London Borough of Havering (20035775) - Correspondence between LB Havering and the Applicant concerning Upminster Cemetery and South Essex Crematorium.

Impact of Lower Thames Crossing (LTC) on Upminster Cemetery and South Essex Crematorium

**Figure 13 - Identified Issues**

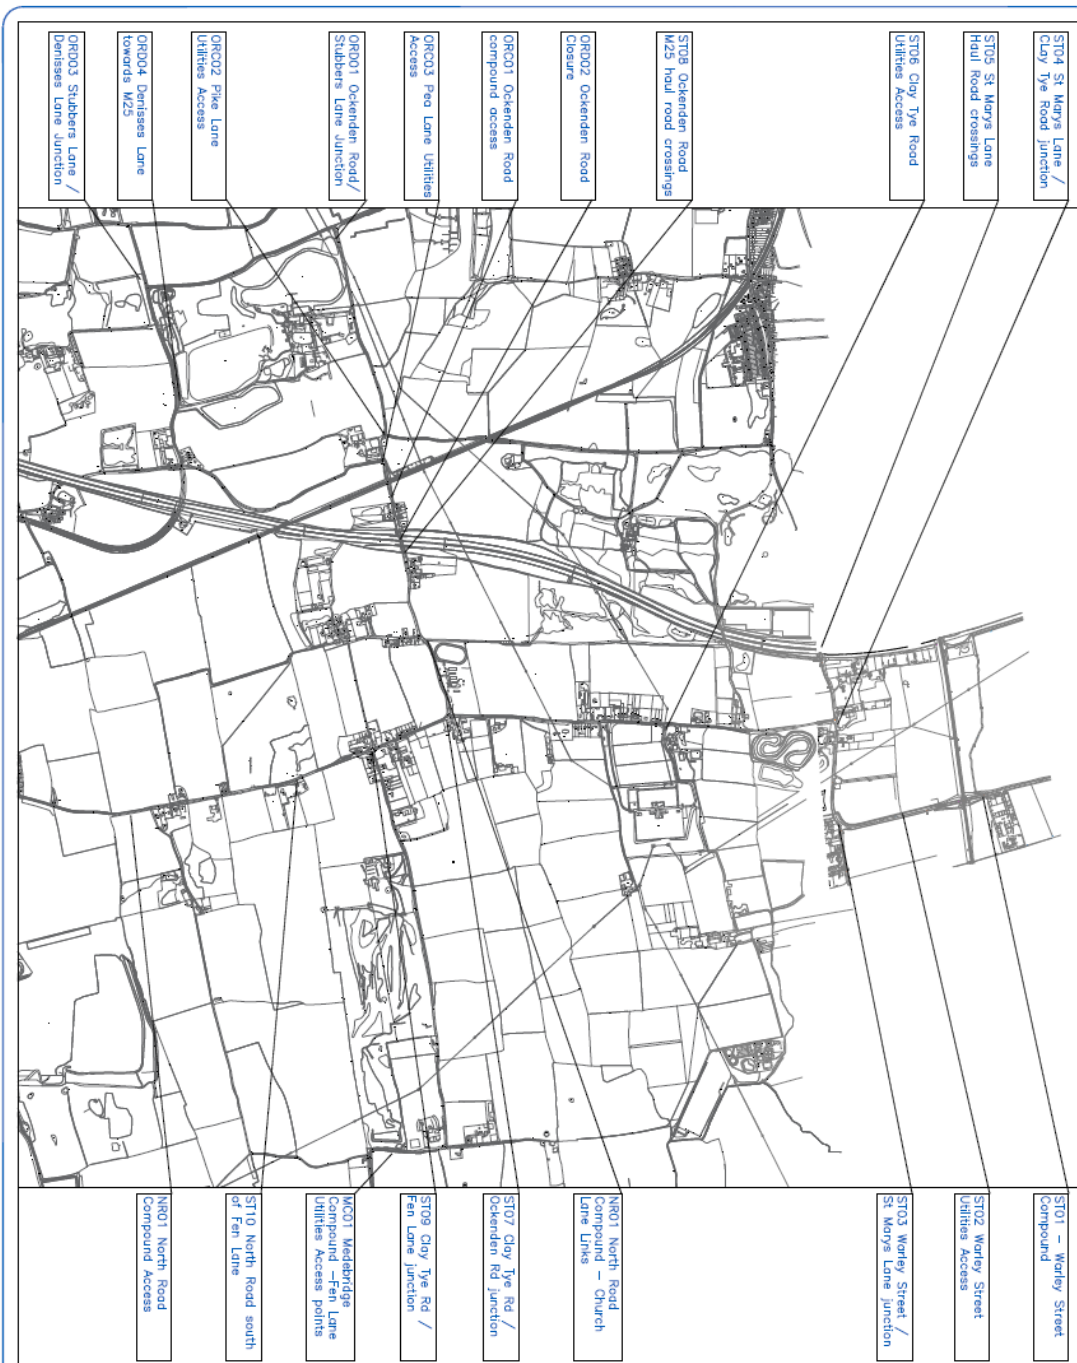
TW SHEET	REF.	LOCATION	ISSUE DESCRIPTION
44	ST03	B186 Warley Street / B187 St Marys Lane junction	<p>Speed limit is 40mph, however speeds likely to be higher due to amenable alignment. Increase in numbers of larger vehicles, moving slower, as a result of construction.</p> <p>Southbound forward visibility appears to be around 100 metres, with northbound visibility slightly more. This does not meet DMRB CD109 requirements however given location, MfS could be applied.</p> <p>Indications of safety concerns with alignment given the physically protected right turn.</p> <p><i>Temporary speed limit reduction may be appropriate to reduce traffic speeds.</i></p>
44	ST04	B187 St Marys Lane / B186 Clay Tye Road	<p>No existing traffic flow data at present to determine dominant movements. HGV movement restricted to west due to LEZ and weight restriction of 3.5t.</p> <p>Rigid HGVs can make the turn at the mini-roundabout, however articulated vehicles will straddle all lanes.</p> <p>Visibility from Clay Tye Road reduced to the east which will not aid movement of larger vehicles.</p> <p><i>Can we improve this junction at all? Traffic control?</i></p>

44	ST05	B187 M25 overbridge – long term haul road crossings to east and west of overbridge	<p>M25 overbridge may reduce visibility – requires 120m at 40mph to DMRB CD109. Vegetation clearance will be required. There has been one serious incident in the vicinity of the easternmost crossing point, in the location of the existing farm access.</p> <p><i>Road crossing arrangement will calm traffic speeds and needs to be clearly signed.</i></p> <p><i>Other notes: hazard of O/H utilities in verges.</i></p> <p>The overbridge clearance height is 4.1m on the warning signage. <i>Is clearance height to M25 overbridge sufficient for movement of any construction traffic?</i></p>
43	ST06	B186 Clay Tye Road – Utilities access at Clay Tye Farm	<p>Mainline is 5.5m wide and speed limit is 40mph. Actual speeds likely to be higher due to straight alignment and lack of junctions. This gate has clearly been used as an access as it has a lockable gate. Access is not shown on OS base.</p> <p><i>How often will this gate be used as all vehicles will swing out into the opposing lane? What vehicles will be used?</i></p>

43	ST07	B186 Clay Tye Road junction with Ockendon Road	<p>Signed from Ockendon Road as 40mph however there is a 30mph gateway to the north of the junction. Visibility from the junction and forward onto the junction appears to meet DMRB CD109 requirements for 40mph at around 200m. Speeds from the south should be reduced by the presence of the new chicane.</p> <p>Turning movements already undertaken by buses and should be fine for articulated vehicles.</p> <p><i>Minimise construction movements to the south since B186 to the south is reduced in width to between 5.0 and 5.5m, plus the route passes through South Ockendon hence the chicane.</i></p>

43	ST08	<p>Construction crossings of Ockendon Road, to east and west of M25 overbridge</p> <p>Temporary closure of this section to all traffic (Ockendon Road diversion considered in Table 2)</p>	<p>Speed limit 40mph, residential properties but not a sense of place. <i>Requirements of DMRB CD109 at 40mph should be applied to the design of crossing points.</i></p> <p>TW drawings indicate that the eastern crossing point is within the M25 overbridge structure footprint. <i>The access point needs to be confirmed. Visibility splays in all directions will need to consider overbridge parapets.</i></p> <p><i>Bus stops to the east of the overbridge will need to be relocated outside the traffic management for the crossing. Temporary bus stops will be required, a new crossing provided between the two bus stops and potentially new footway to access the bus stops.</i></p> <p><i>More detail required on the PROW diversion to the south and how this will link to the bus stops that are relocated.</i></p> <p><i>Turning vehicles out of the crossing points may cause concern swinging out into traffic since overbridge structure restricts movement. This <u>may</u> only be a hazard outside of the period when the temporary closure is in place since after this, only 'crossing' of Ockendon Road is required.</i></p>

42	ST09	B186 Clay Tye Road, junction with Fen Lane	<p>Fen Lane is narrow and not appropriate for numbers of larger vehicles. Access for utilities to be taken from the Medebridge compound further south (see table 5). Vehicles larger than a rigid HGV will struggle to make the turn into Fen Lane safely.</p> <p><i>Ensure that utilities construction access is not taken down Fen Lane.</i></p>
42	ST10	B186 North Road between Fen Lane and M25 Compound Access	<p>30mph in South Ockendon rising to 40mph at a gateway 235 metres south of Fen Lane. Traffic speeds likely to be higher given straight alignment. Mainline is 6.0m wide which is ok for two larger vehicles to pass but not at high speed. Serious accident at Helipad Road junction (no details).</p> <p><i>Minimise construction traffic movements along this section.</i></p>

TW SHEET	REF.	LOCATION	ISSUE DESCRIPTION
43	ORD01	Ockendon Road junction / with Stubbers Lane	<p>Diversion of traffic including all non-construction HGV, buses (service 370) and farm vehicles.</p> <p>40mph speed limit on all approaches, ghost island for right turners into Stubbers Lane.</p> <p>Two serious incidents here in last 5 years.</p> <p>Forward visibility around bend on Ockendon Road is around 50m or less. Forward visibility onto Stubbers Lane from the east is also not to standard. <i>DMRB CD109 visibility requirements apply here.</i></p> <p>Regards turning, larger vehicles cannot use the right turn pocket effectively so will be waiting in the middle of the road.</p> <p><i>Junction arrangement needs to be reviewed for duration of the works. Could priorities be changed? Traffic island will need to be removed to facilitate all movements by larger vehicles.</i></p> <p>Stubbers Lane is approximately 5.0m in width although it narrows immediately north of the junction with Dennises Lane due to a tree within the verge.</p> <p>5.0m would not be considered sufficient to allow passing of 2 larger vehicles on a frequent basis and would lead to deterioration of highway edges and verges.</p> <p>Forecast traffic flows are shown to increase traffic on Pike Lane and Pea Lane rather than Stubbers Lane i.e., not reflective of the diversion in place. The appropriateness of Pike Lane and Pea Lane are discussed in more detail in Table 8 below.</p>

42	ORD03	Stubbers Lane junction / with Dennises Lane	<p>Both have centreline markings indicating that they are at least 5.0m in width. However, this is not acceptable width for two large vehicles passing.</p> <p>Stubbers Lane at this end, is the start of the LEZ. 40 mph on both roads.</p> <p>Forward visibility onto junction from Dennises Lane in each direction should meet DMRB standard.</p> <p>Visibility from Stubbers Lane is very much reduced by vegetation but not easily measured from OS Base. The southbound approach to the junction is also very narrow. Two large vehicles on Stubbers lane will struggle to pass each other particularly at the pinch point.</p>

42/43	ORD05	General Note	<p>The above issues ORD01 to ORD04 indicate concerns with the diversion route.</p> <p>The diversion will be in place for a number of months. It is not clear what the diversion route would be in the occurrence of a closure of Stubbers Lane, Dennises Lane and B186 North Road / Clay Tye Road, since it has been shown that Pea Lane, Pike Lane and Fen Lane are not considered appropriate as diversion routes.</p>
-------	-------	---------------------	--

I note the Council's detailed concerns about resilience of its roads forming part of proposed diversion and construction access routes. During the remainder of the DCO examination period, our Negotiations and Construction teams will work constructively with the Council to explore these concerns. This will lay a firm foundation for dialogue, which you rightly observe will continue after the examination.
